**Re:** Planning Application 18/1086

**Address:** Kitchen Green Farm Preston Road Ribchester PR3 3XL

**Description:** One new vertical, double-sided V sign and two horizontal signs.

R Seed, Kitchen Green Farm – Farm Plan 1

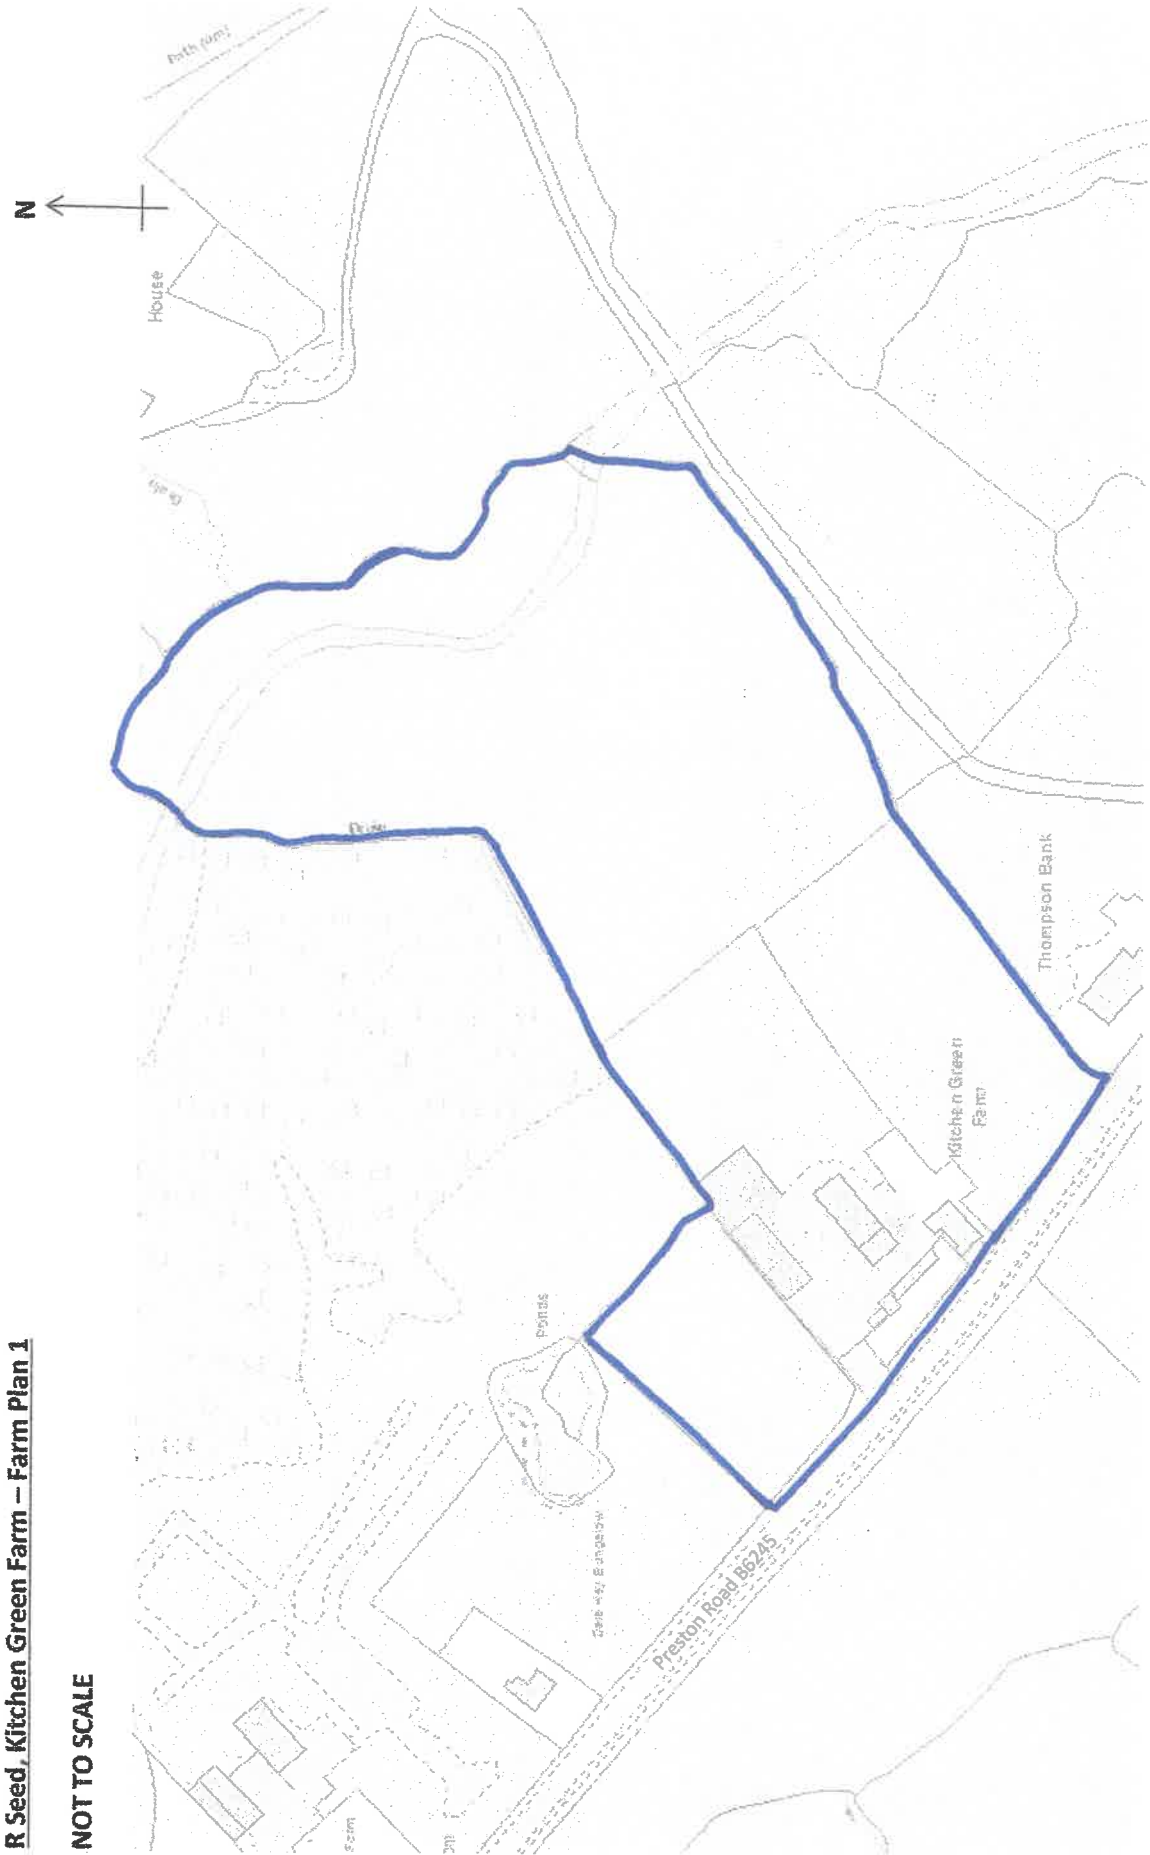
With respect to this application we would wish to raise an objection to the proposed signage.

The signage is to be positioned within the boundaries of the adopted highway this is not acceptable.
